**Planning Application 6/2021/0079/FULL
8 Hill Rise, Cuffley EN6 4EE**

I write on behalf of Mr C Theodorou, the occupier of the neighbouring property at 6 Hill Rise, to raise objection to the above application seeking planning permission retrospectively for the erection of a dwelling (revisions to planning permission Ref 6/2018/0383/FULL).

| Sheet Title | As Built Loft Floor and Roof Plans |

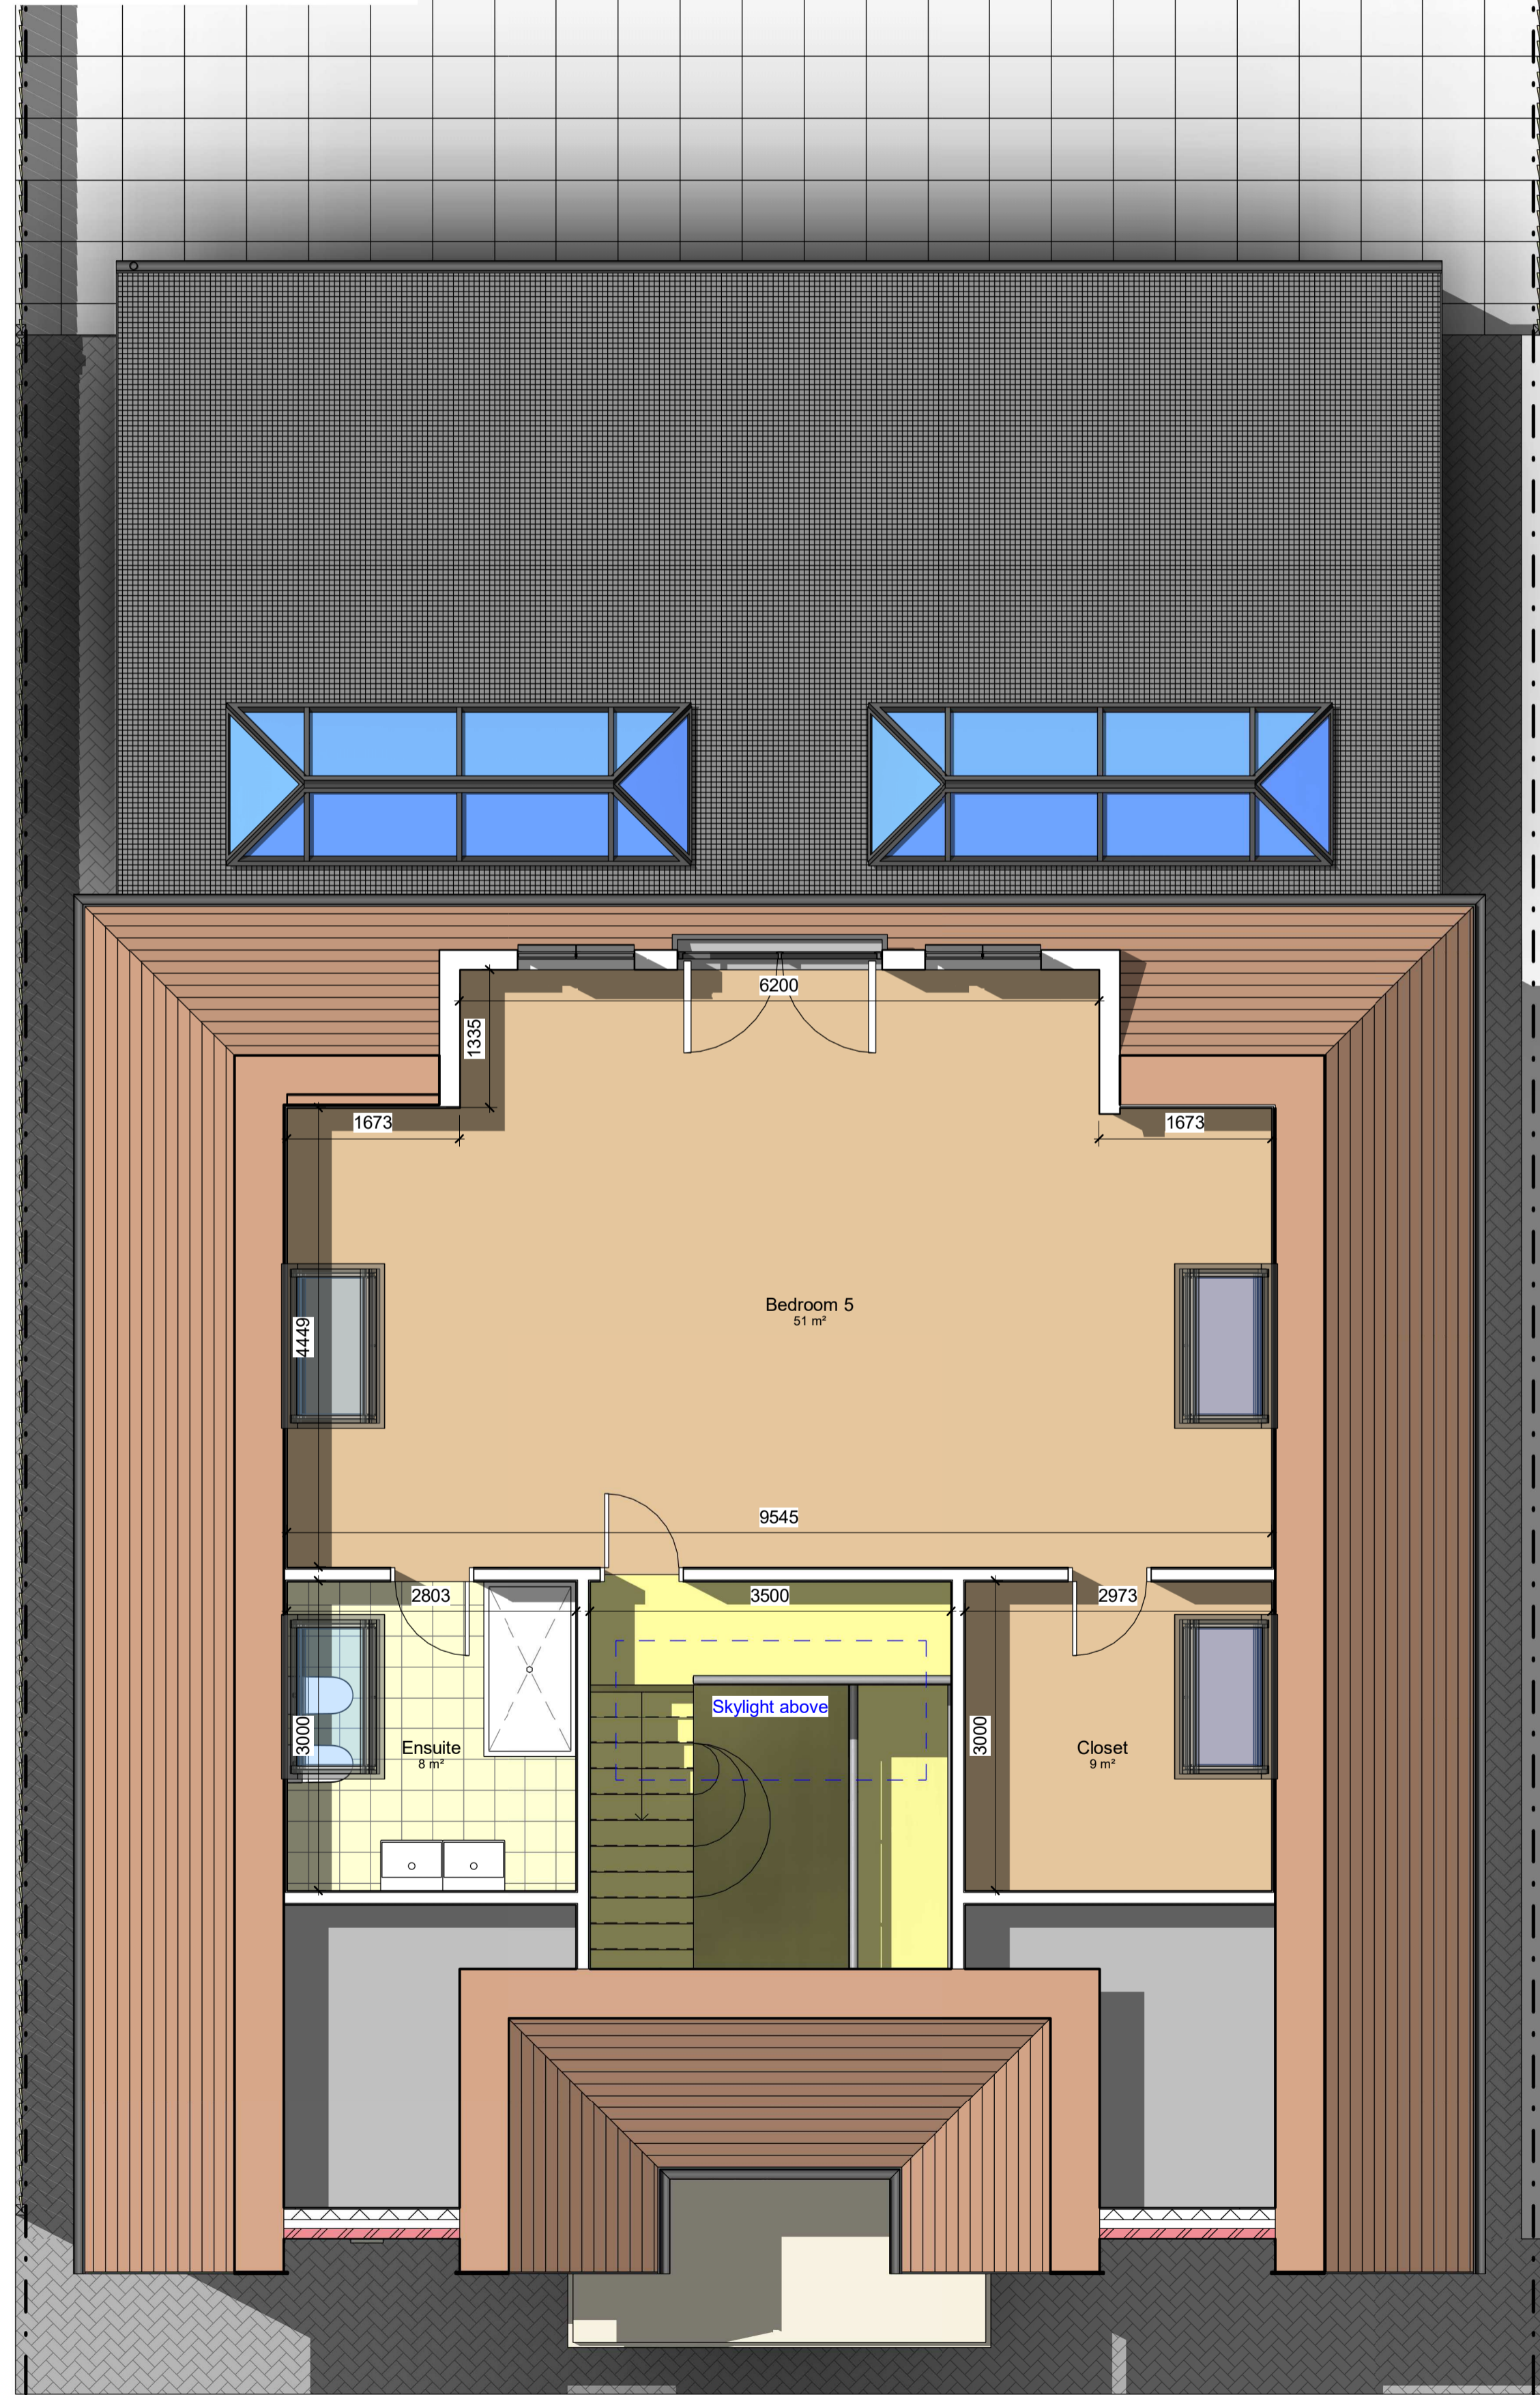
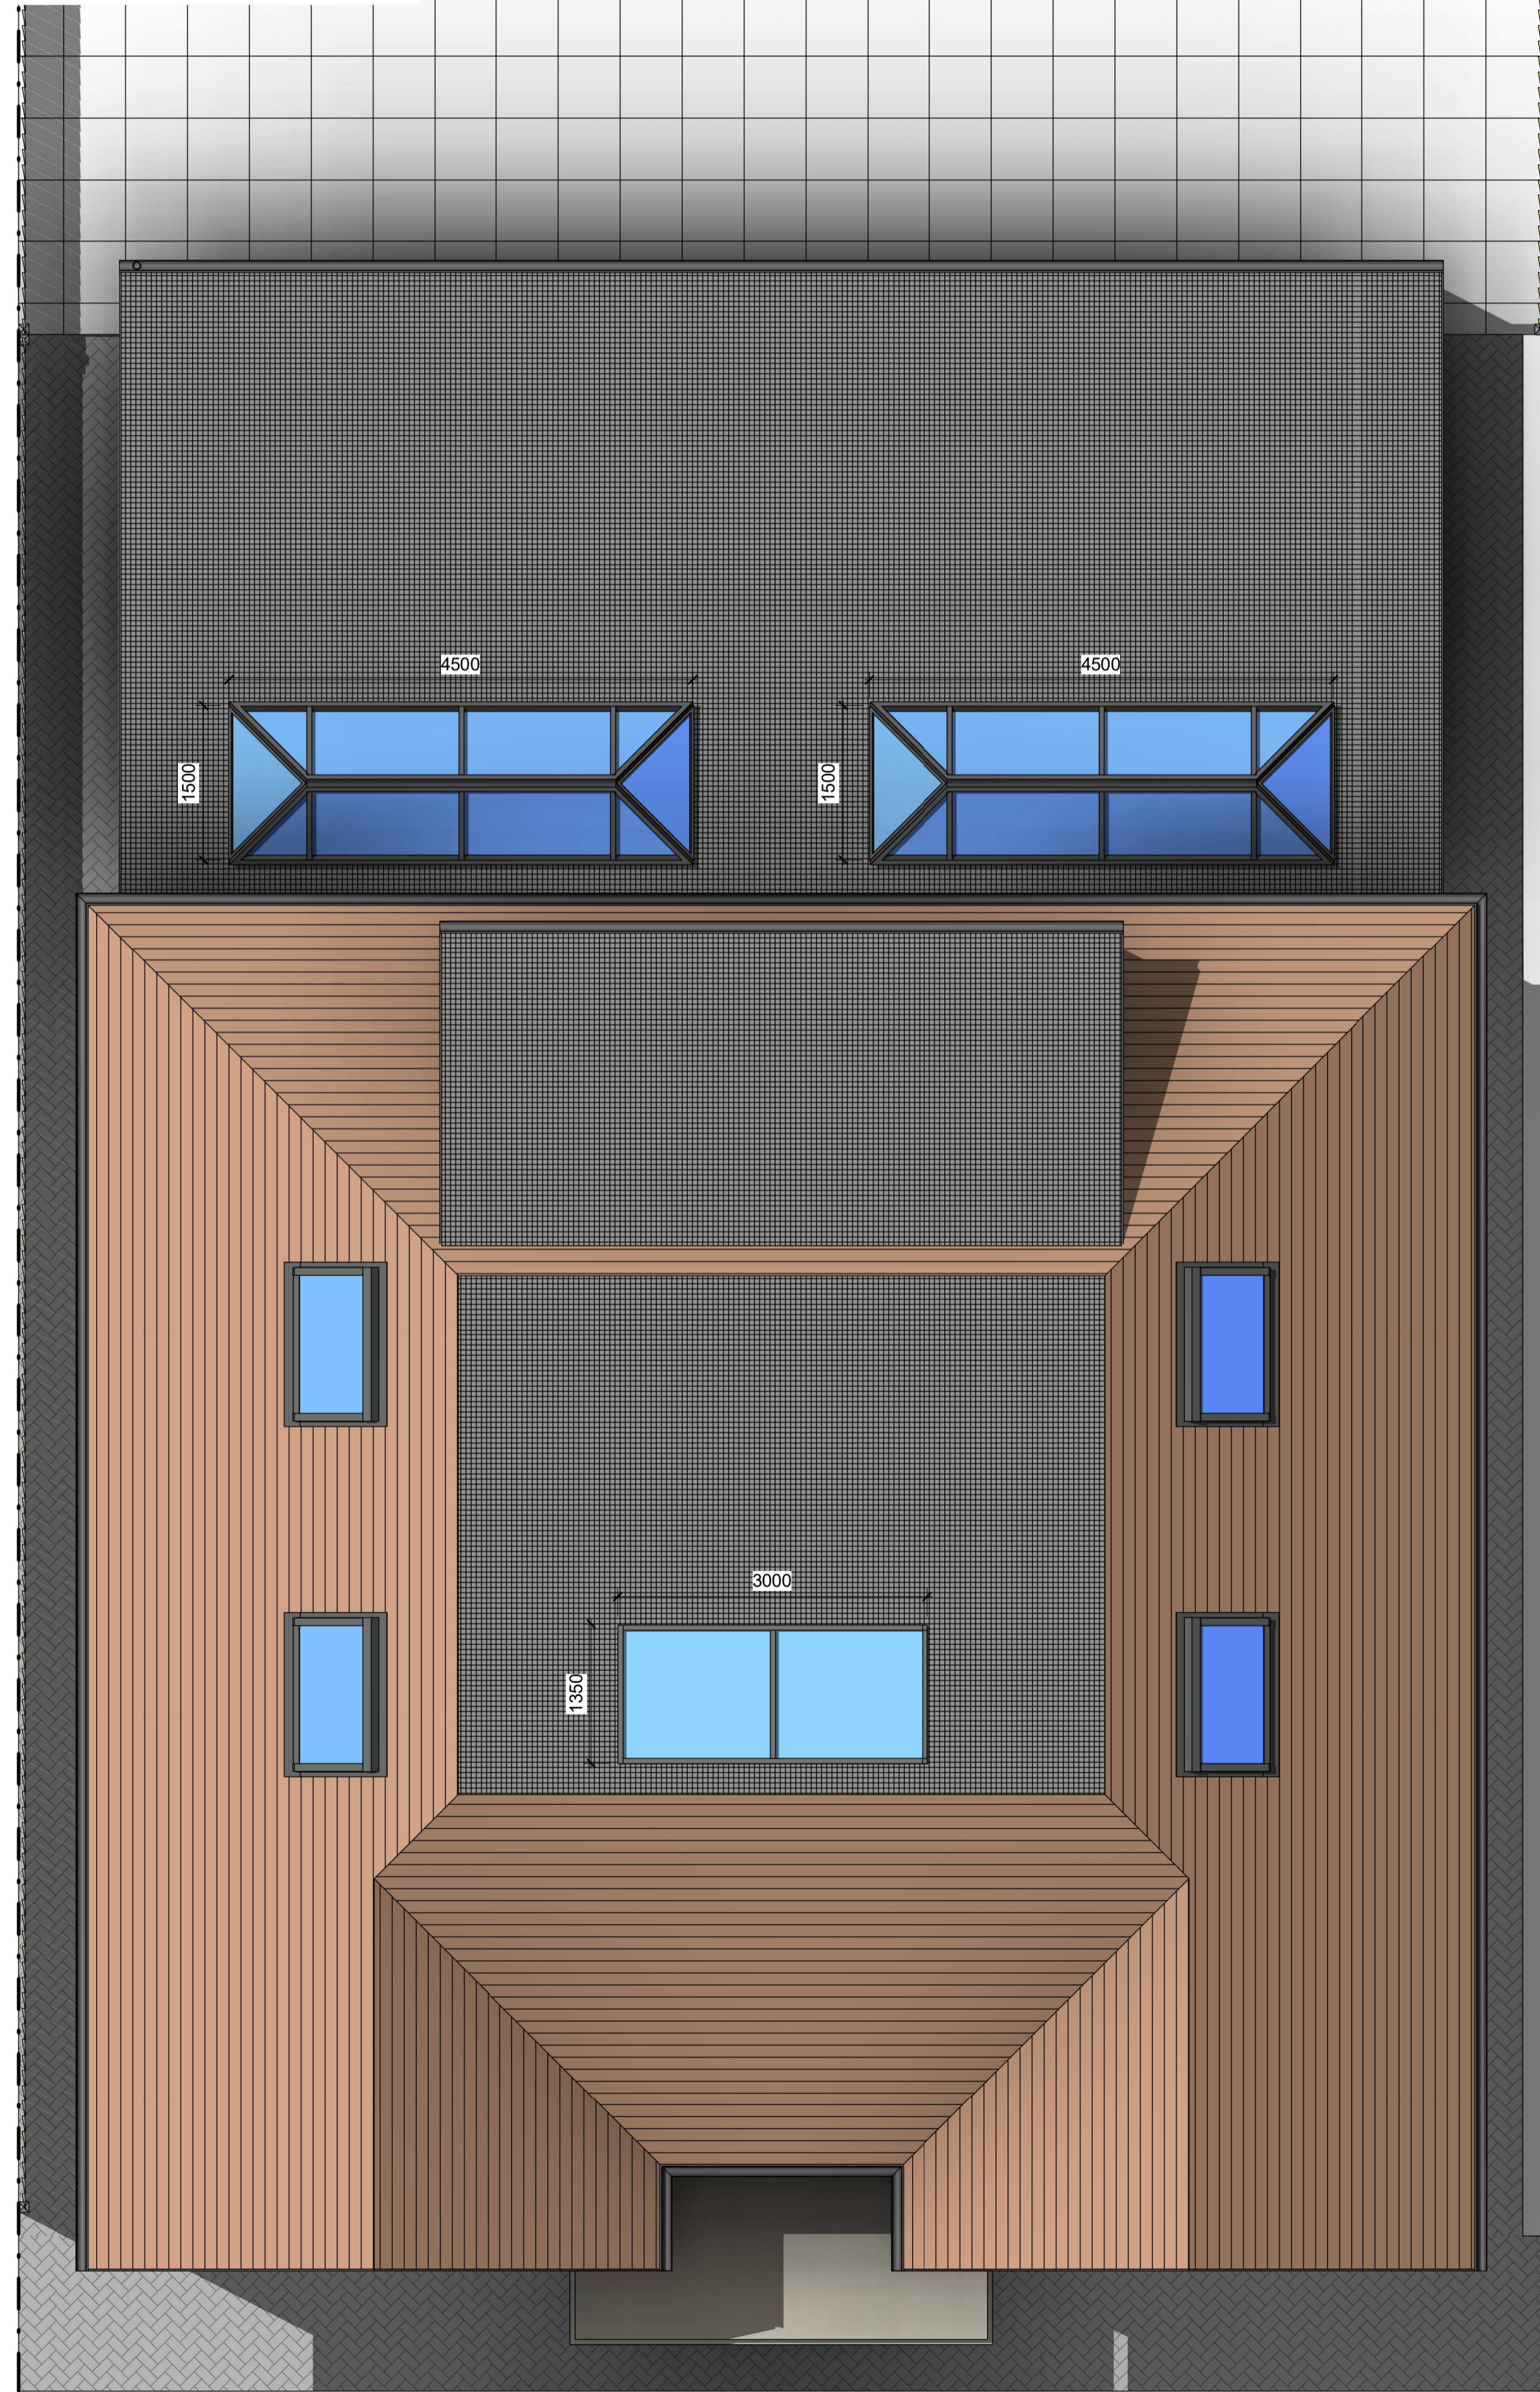
Whilst not necessarily a matter that directly affects my client's property, it should also be noted that the rear loft windows/doors should have been fitted with glass balustrades. You will note that these have not been installed, creating a significant risk of falling for the occupiers of No 8. Such an arrangement cannot be acceptable under the Building Regulations.
